City of Portland, Maine - Building or Use Permit Application
 389 Congress Street, 04101 Tel: (207) 874-8703, Fax: (207) 874-8716

Permit No: 07-1435	Issue Date:	CBL: 081 C001001
------------------------------	--------------------	----------------------------

Location of Construction: 122 PITT ST	Owner Name: RUSSO LOUIS	Owner Address: 122 PITT ST	Phone:
Business Name:	Contractor Name: MR Brewer Fine Wookworking	Contractor Address: 91 Bell Street Portland	Phone 7977977534
Lessee/Buyer's Name	Phone:	Permit Type: Additions - Dwellings	Zone:

Past Use: Residential Single Family Home.	Proposed Use: Residential Single Family Home with attached garage.	Permit Fee: \$1,620.00	Cost of Work: \$160,000.00	CEO District: 2
Proposed Project Description: Construct a new 1749 square foot garage.		FIRE DEPT: <input type="checkbox"/> Approved <input type="checkbox"/> Denied	INSPECTION: Use Group: Type	
		Signature:	Signature:	
PEDESTRIAN ACTIVITIES DISTRICT (P.A.D.)				
Action <input type="checkbox"/> Approved <input type="checkbox"/> Approved w/Condition <input type="checkbox"/> Denied				
		Signature:	Date:

LONG SECTION
SCALE: 1/2" = 1'-0"

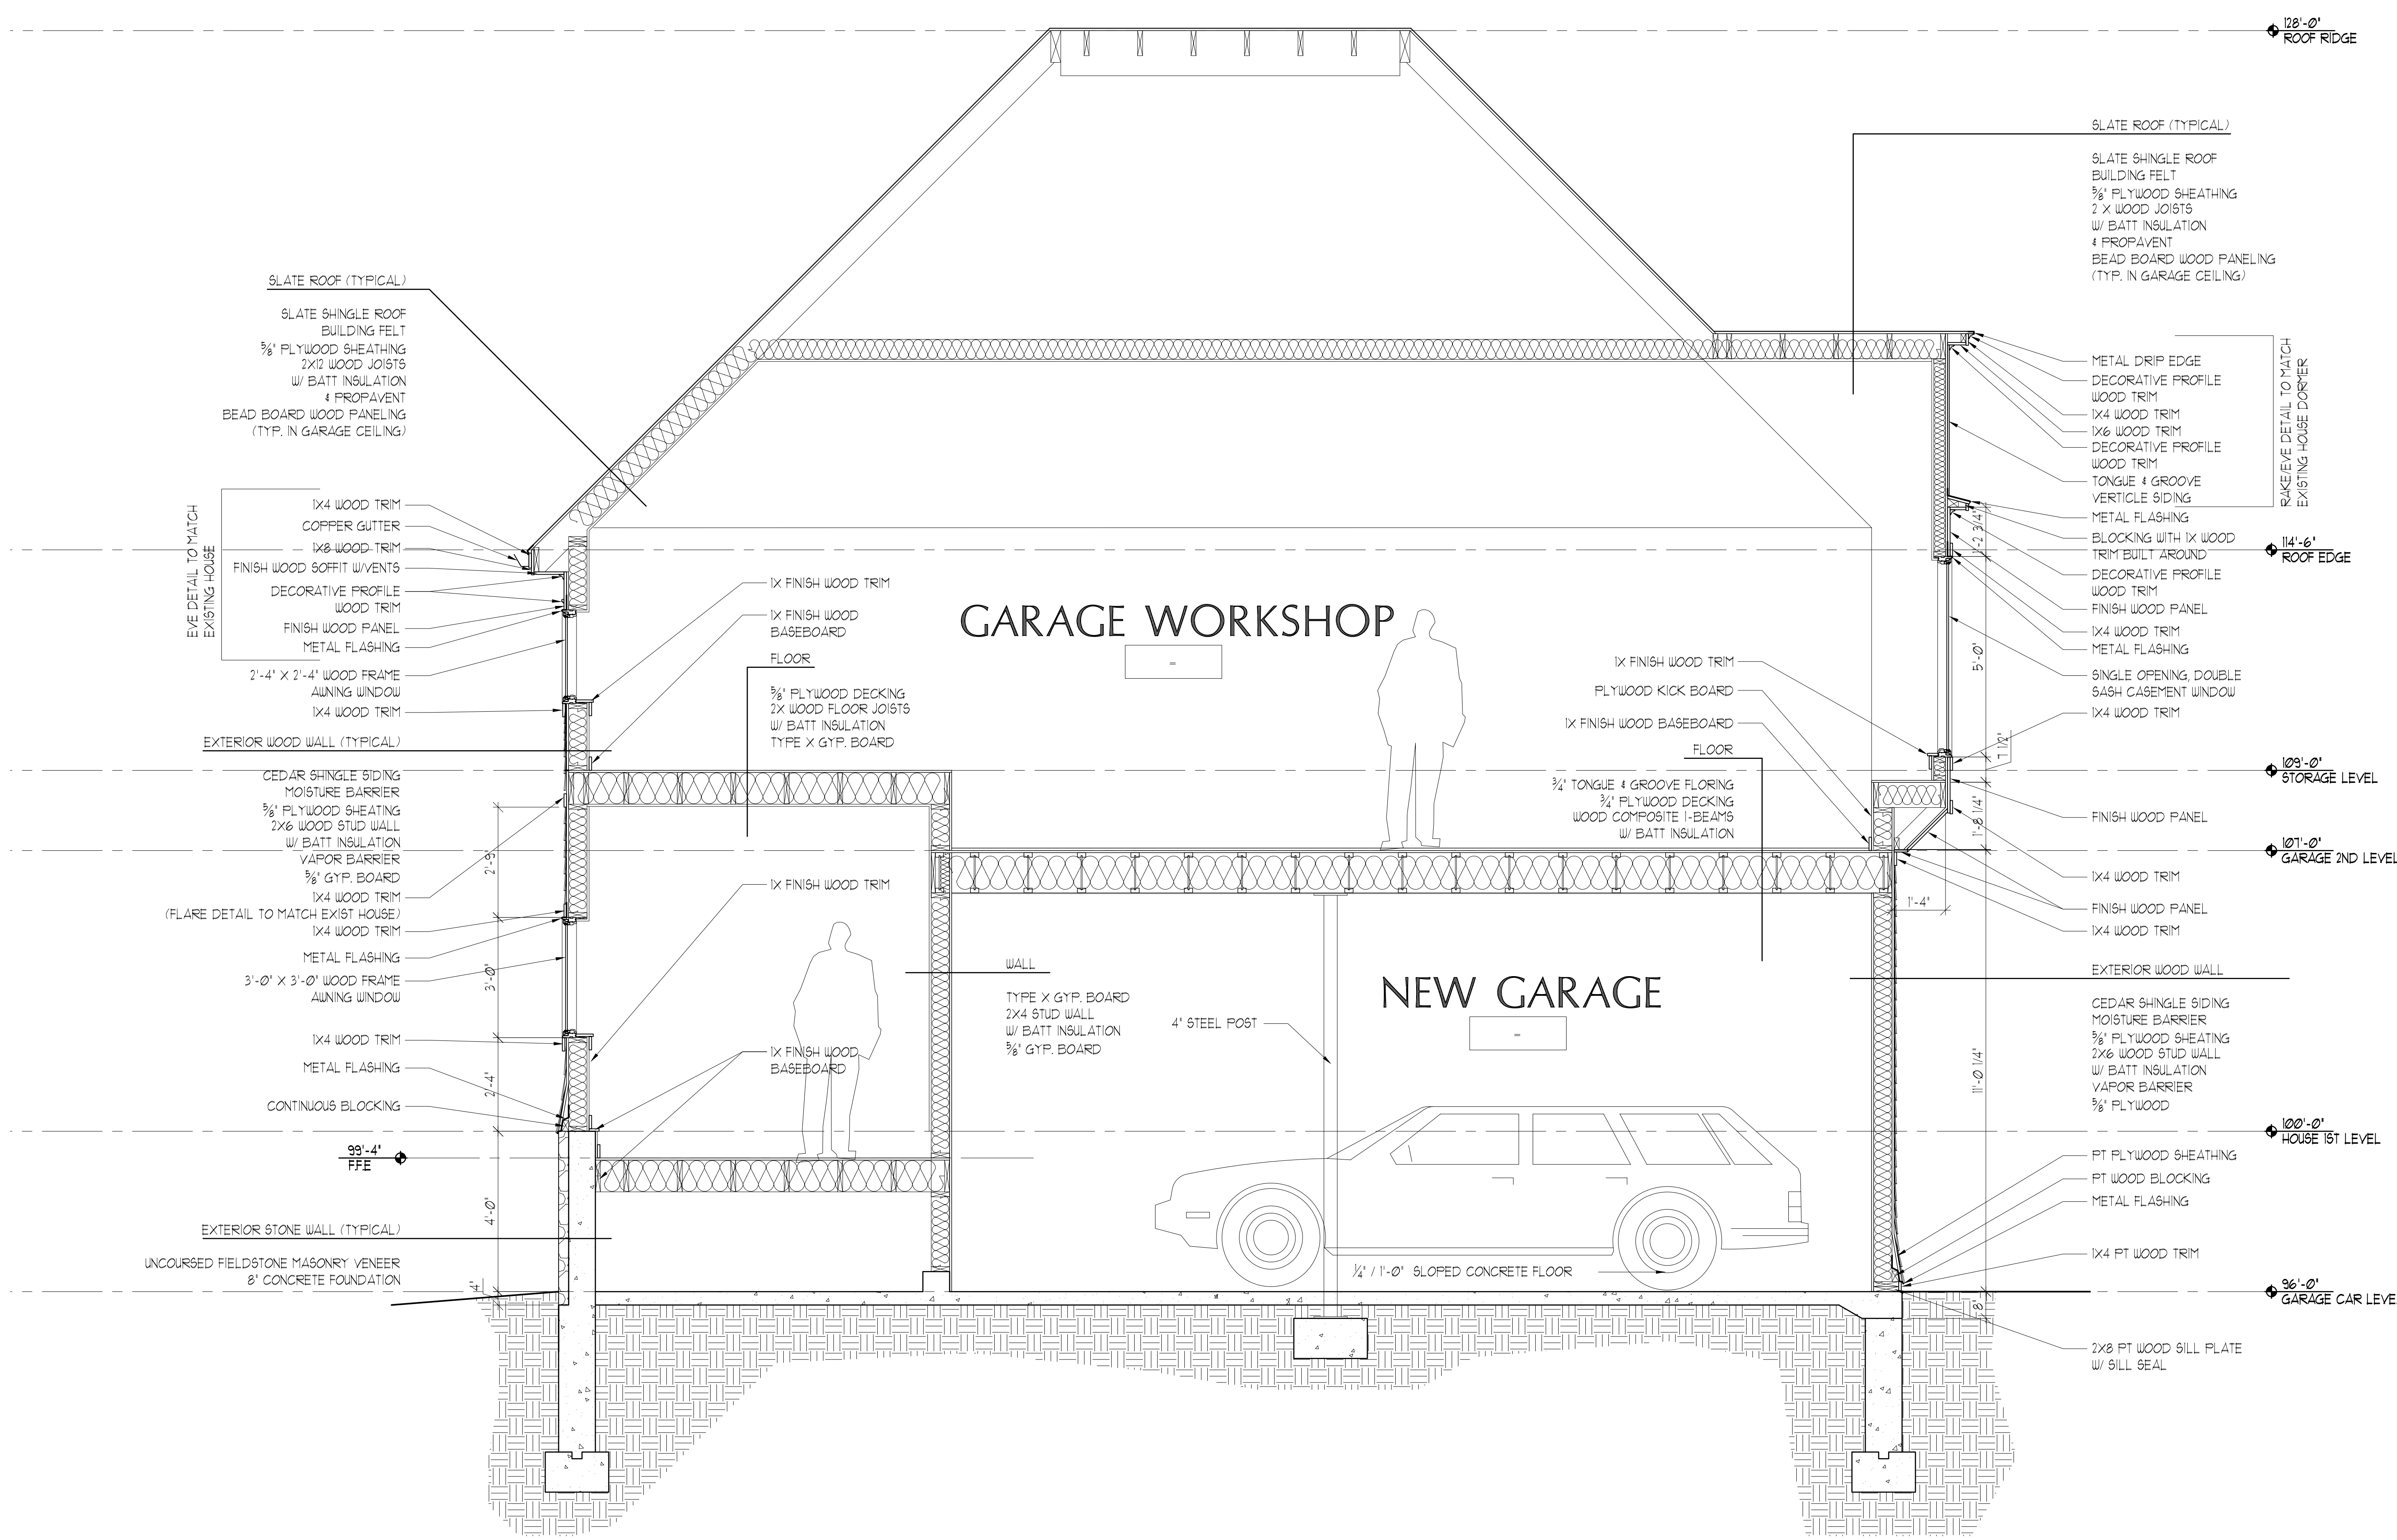
Note: Need eng. Detail of roof rafter and collar ties. Called Matt he will send via fax. **Ok to Issue:**
